UPDATE OF LIST OF PLANNING APPLICATIONS TO BE DECIDED BY

Planning Application 2026/90484

Change of use from dwelling to C2 for 4 children, erection of first floor extension and front porch, internal and external alterations

143, Church Lane, Gomersal, Cleckheaton, BD19 4QN

Proposed Site Layout 1:100

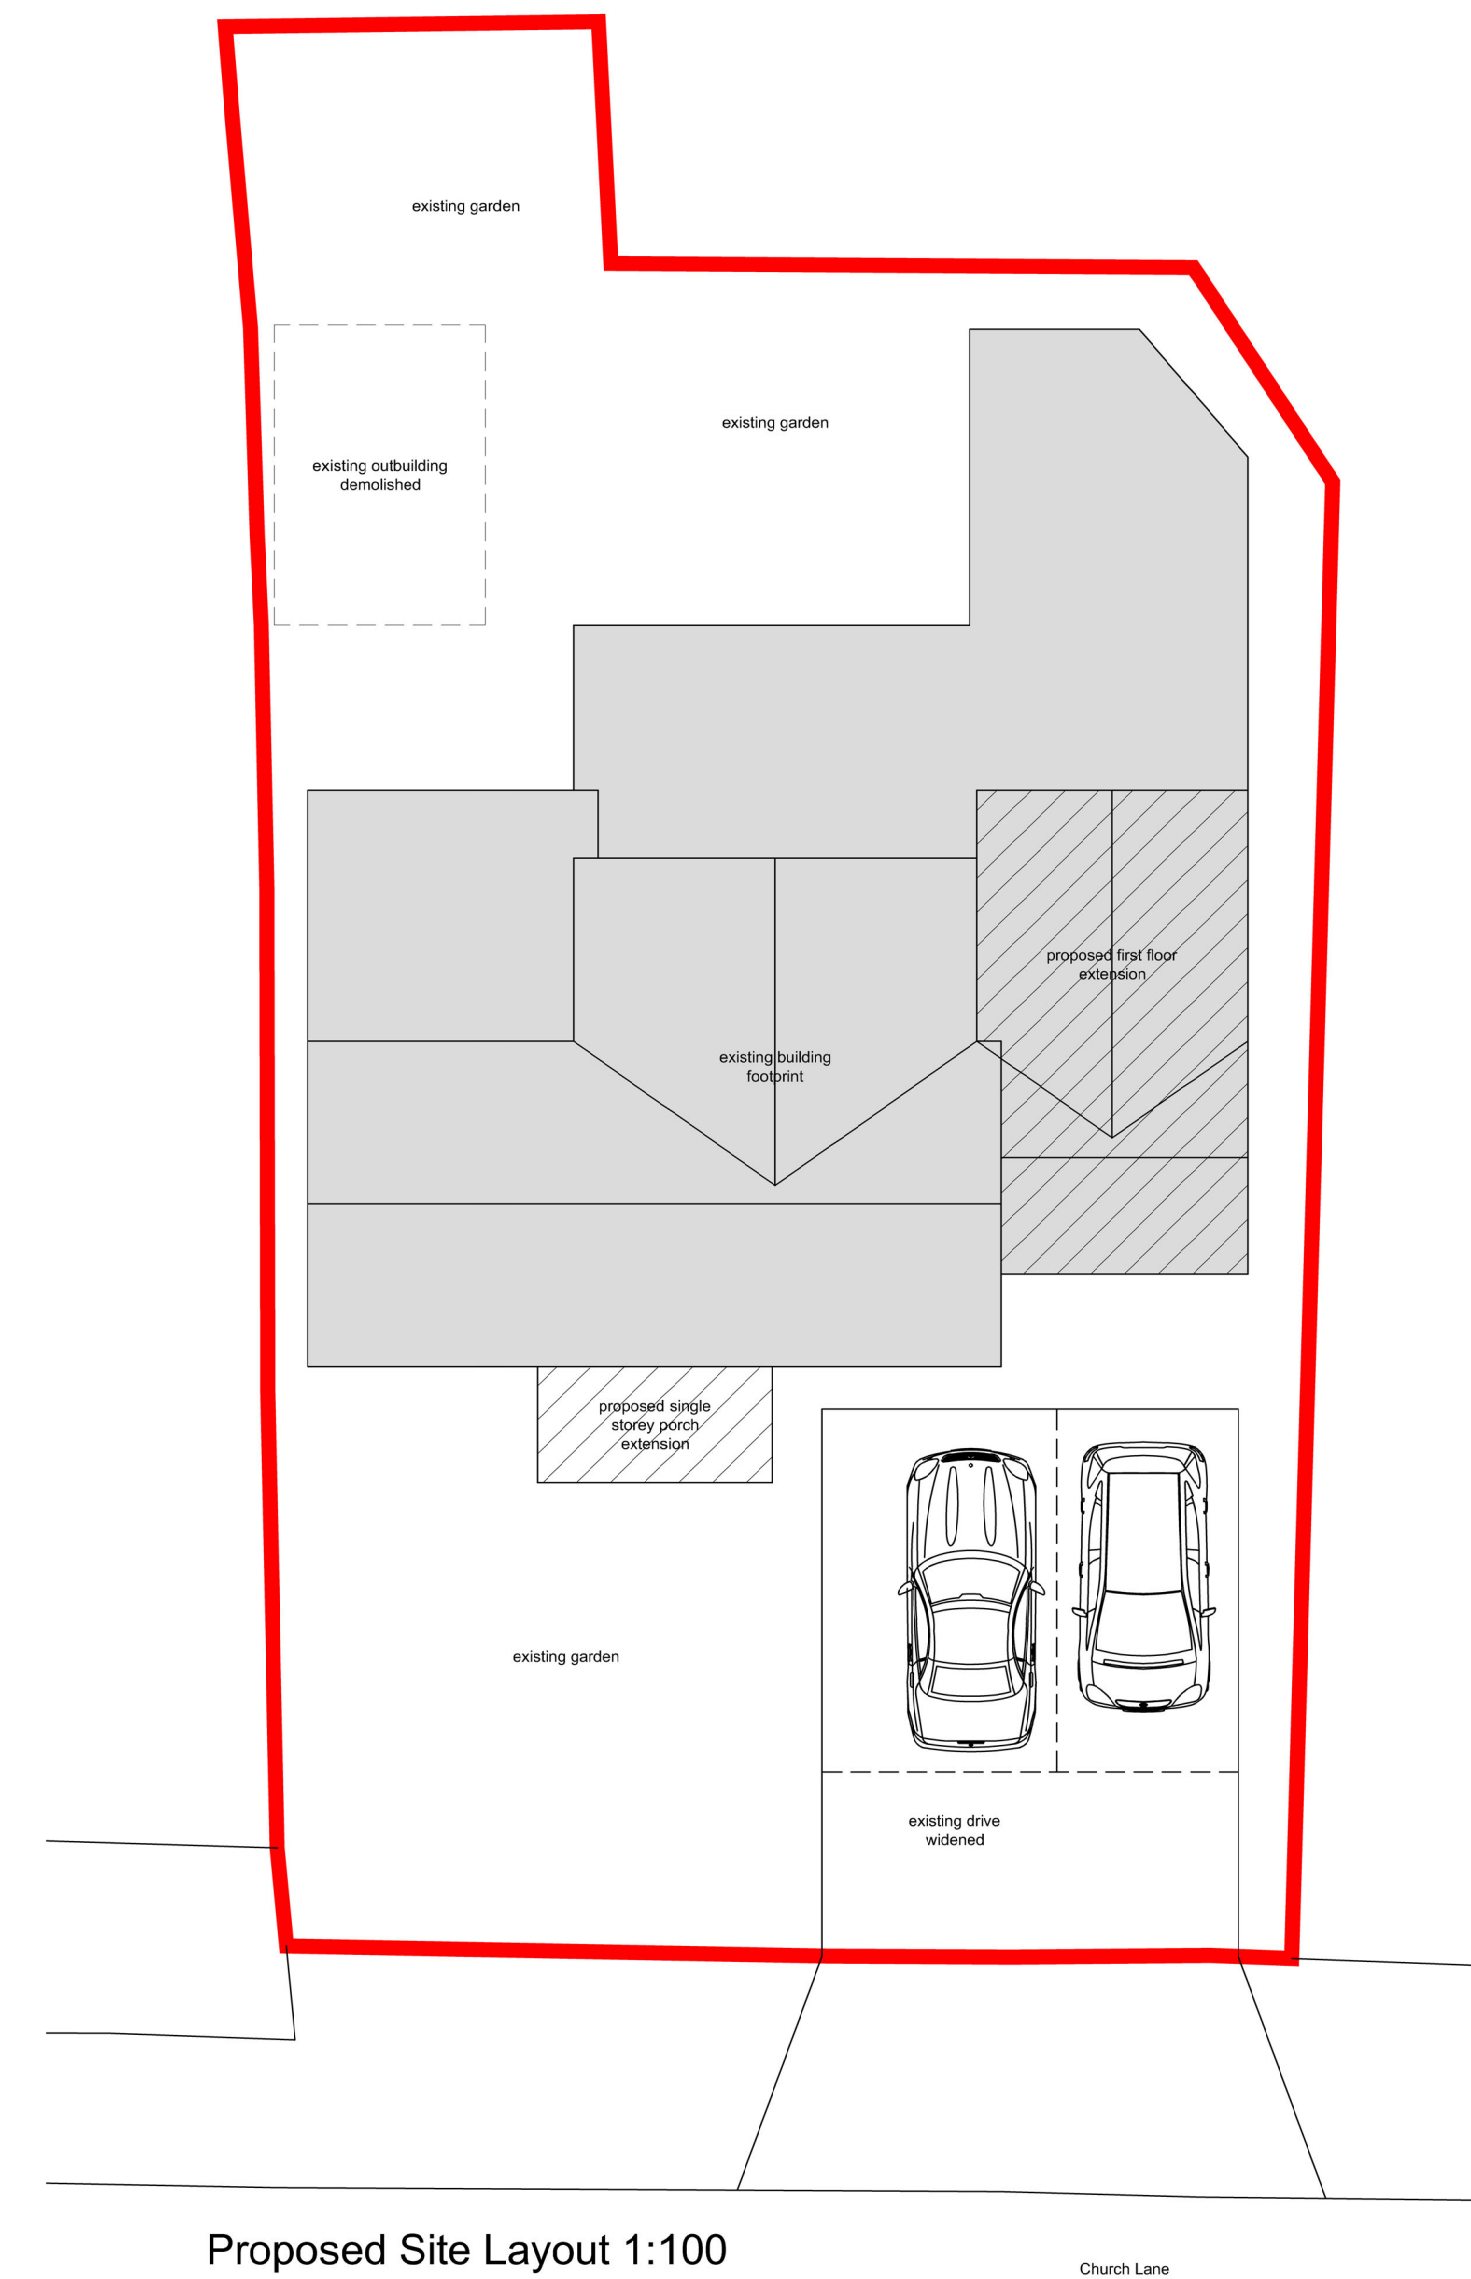
Parking- the property has created 2 parking spaces, however Kirklees guidelines state a property of 4 bedrooms or more should have a minimum of 3 off road space. Using the destroyed council grass verge and footpath can in no way be classed as off-road parking.

Applicant's claim: The **frontage provides up to four vehicles**, including a double-width drive and additional hardstanding.

Correction or qualification: **Only two vehicles are depicted on the revised site plan** and the officer report acknowledges two spaces. The ownership, legal status, dimensions and access to any additional hardstanding are not demonstrated.

With regard to parking provision, the site benefits from two formal off-street parking spaces within the curtilage of the property. In addition, there is capacity for on-street parking. It is also noted that the agent has submitted a Parking Management Plan which sets out arrangements for staff and visitors, including instructions regarding parking practices and expectations for site users. Taking these measures into account, together with the nature and scale of the proposed use, officers are satisfied that adequate parking provision would be available and that the development would not give rise to unacceptable highway safety or parking impacts.

A dimensioned parking layout showing usable spaces wholly within the site
Officer Response: The submitted site plan clearly identifies the parking area available within the site. The layout provides sufficient information to assess parking provision and vehicle manoeuvring.
